From: [REDACTED]
Sent: 24 August 2023 09:56
To: Planning
Cc: [REDACTED]
Subject: Re: Planning Application Reference No. 3/2023/0623

Re: Planning Application Reference No. 3/2023/0623
Applicants: Mr & Mrs Haley
Property: 95 Chatburn Road, Clitheroe, BB7 2AS
Your Email Response Address: planning@ribblevalley.gov.uk

Client: Mr & Mrs Haley		
Project: Proposed Orangery 95 Chatburn Road Clitheroe		
Dwg title: Proposed Ground Floor Plan		
Scale: A5: 1:50	Date: 02.08.23	Drawn by: PD
Drawing no. 1485 - 04	Rev. -

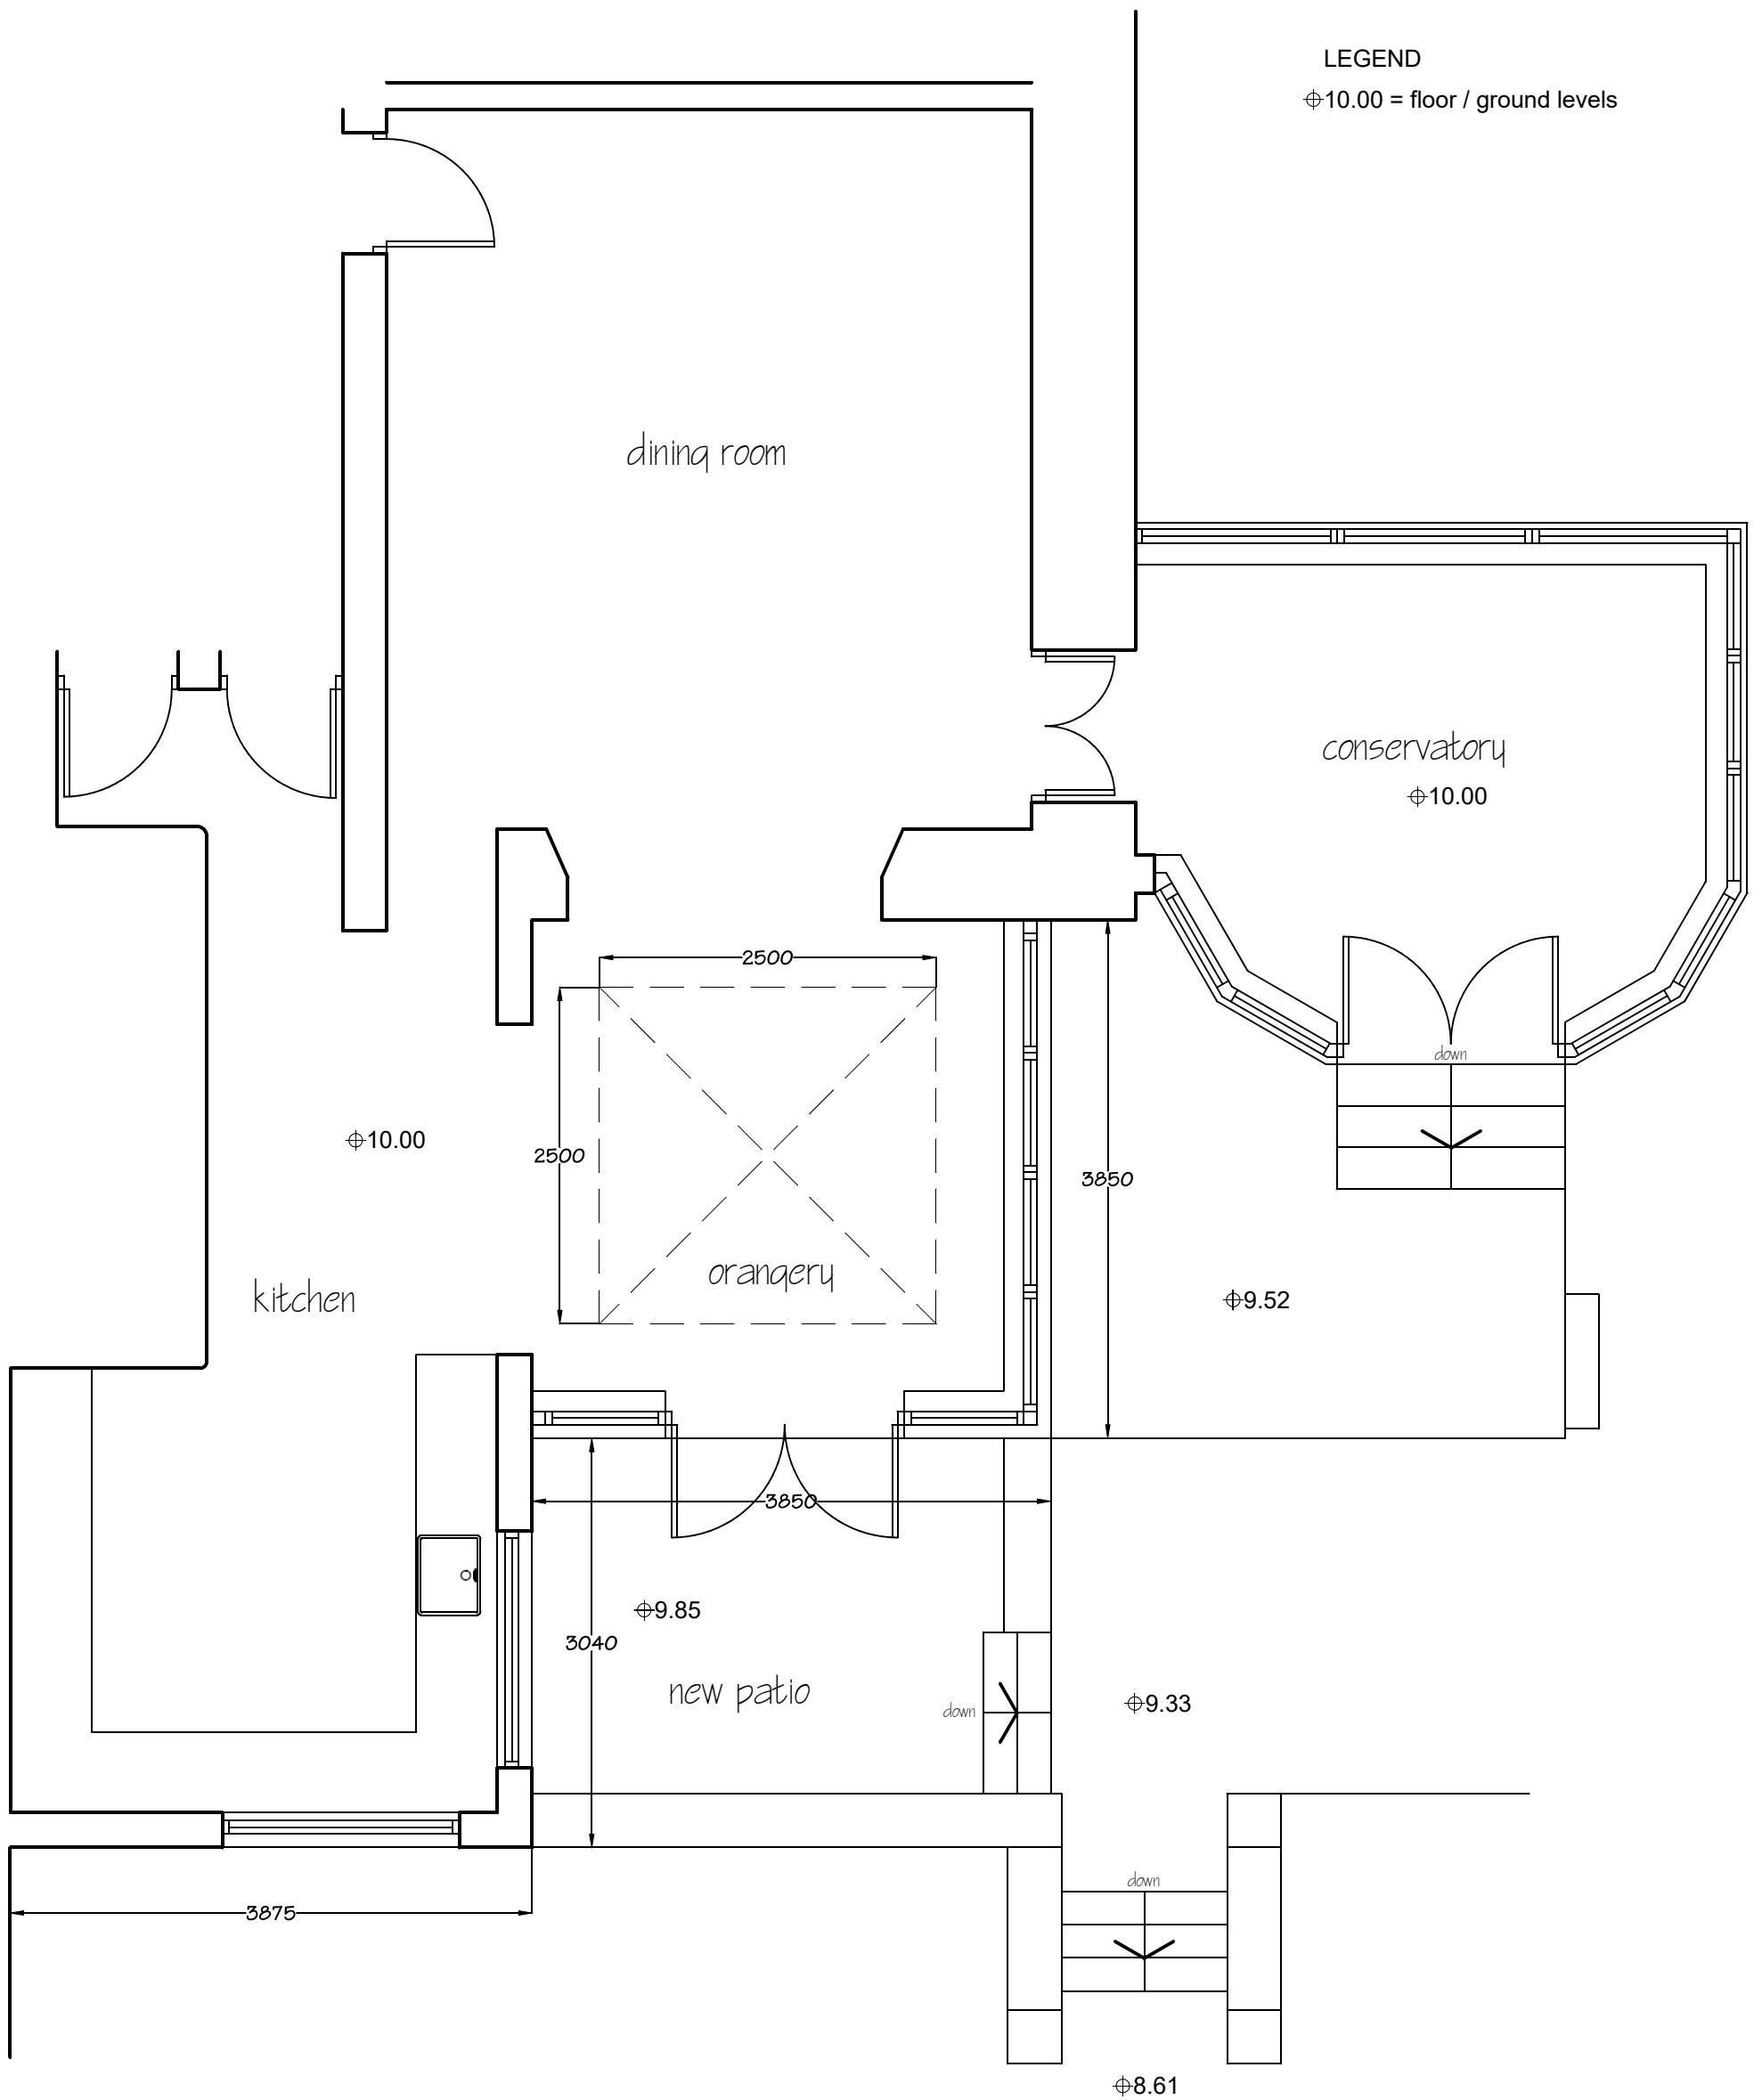
The primary reason for our stance in this matter relates to the point that the proposals appear from the plans to involve the removal of the entirety of the existing pitched grey slated roofing which is located over the existing kitchen of 95 Chatburn Road.

Any proposal that involves the removal of the existing pitched grey slated roof [REDACTED]
[REDACTED] as well as the style and visual impact on the [REDACTED]
[REDACTED]

As the proposals stand, we therefore wish to register our formal objections to the proposed plans involved in this application, most particularly in so far as they affect the existed pitched slated roofing over the kitchen to No. 95 Chatburn Road and the proposed removal of it.

In an effort to assist in constructive further deliberations over these proposals, perhaps there maybe some flexibility for the plans to be amended to reflect [REDACTED] with an amended proposal that retains a significant part of this existing pitched slated roofing so that the integrity of this roofing [REDACTED] down towards an area of flat roofing around the proposed lantern located over the proposed Orangery. This would also leave the ridge of the existing kitchen roof and the pitched elevation of it [REDACTED]

We wonder whether this may work with a smaller area of flat roofing around the lantern area? If so, this would result in the retention of the existing grey slated pitched roof that [REDACTED]
